**Re: Circle K – Eagle Ranch & Irving at 9610 Eagle Ranch Blvd NW
Erosion and Sediment Control Plan
Engineer's Stamp Date – 1/2/2024 (C13E028)**

Based upon the information provided in your submittal received 1/5/2024, the above referenced ESC Plan cannot be approved until the following comments have been addressed.

**EROSION CONTROL PLAN - INITIAL**

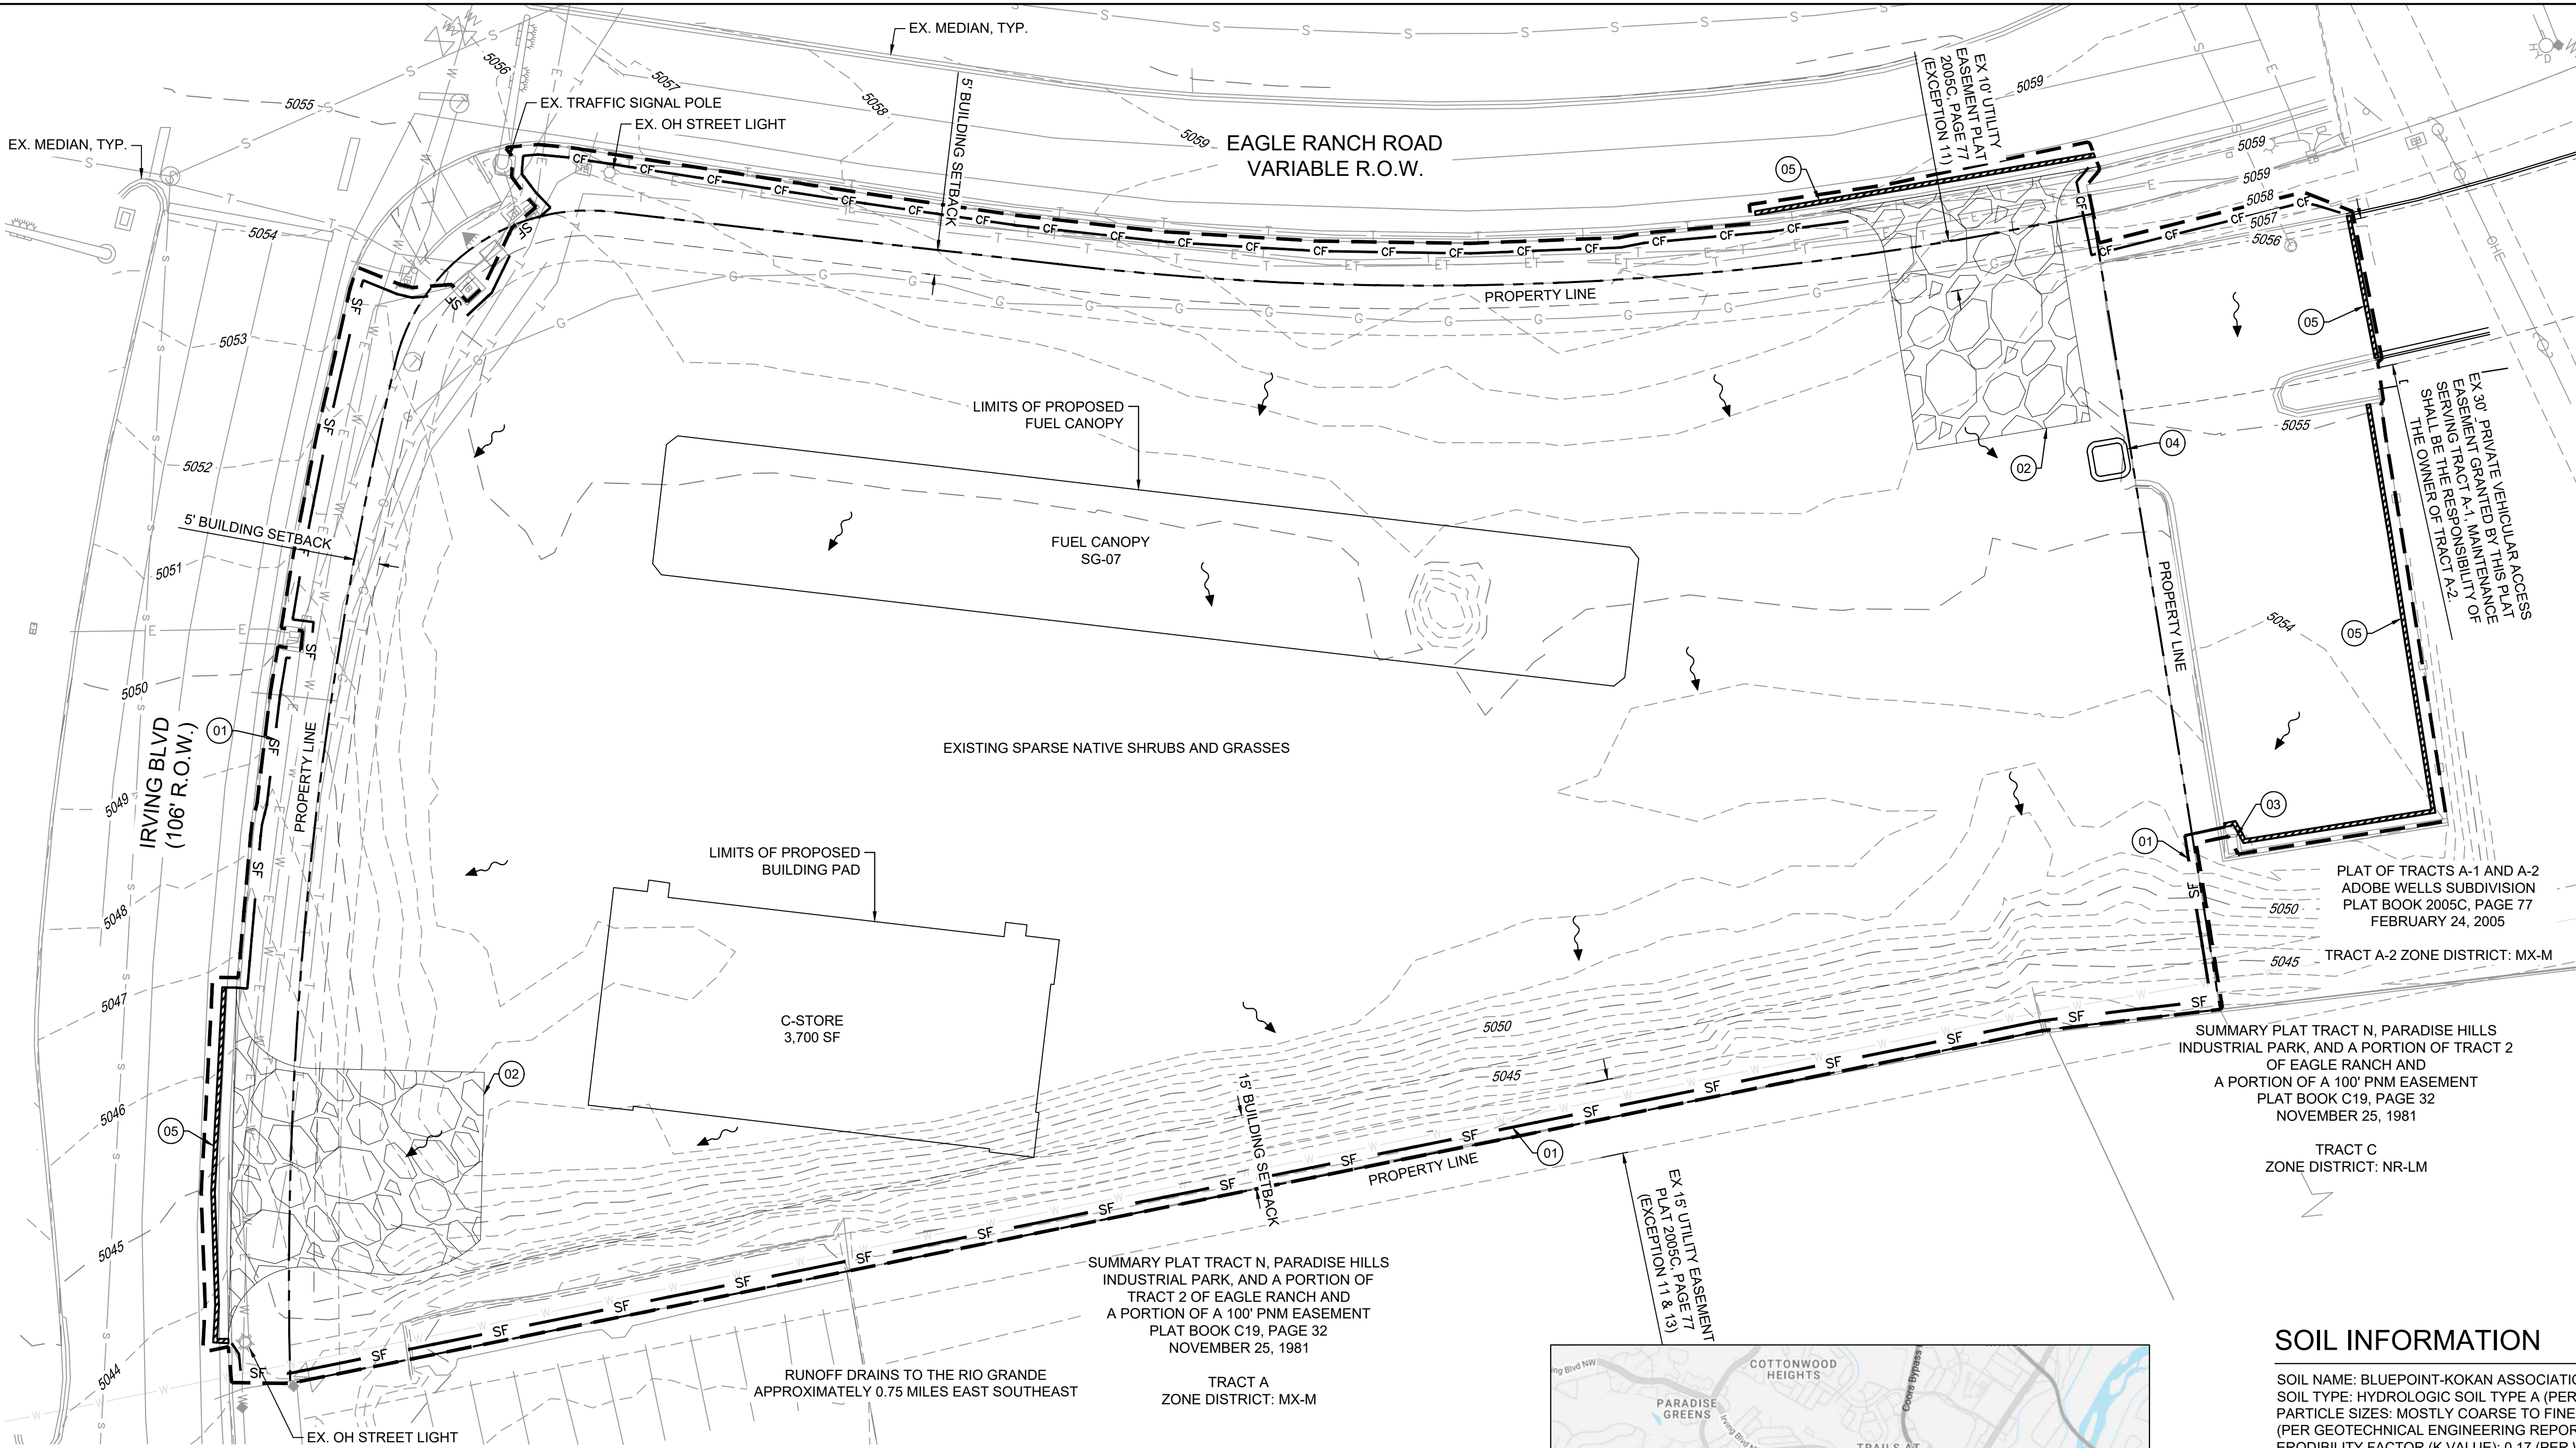
1. This plan shows a large gap in the silt fence at the low corner where you have located the southwest construction exit contrary to CGP 2.2.3 and contrary to standard Erosion and Sediment Control (ESC) practices. You must revise the design of your BMP controls to ensure that stormwater runoff is ponded before it leaves the site in accordance with CGP 2.2.3. At a minimum provide continuous silt fence across the low corner with no gaps. The construction exit located at the high corner of the site, the northeast corner, is acceptable.
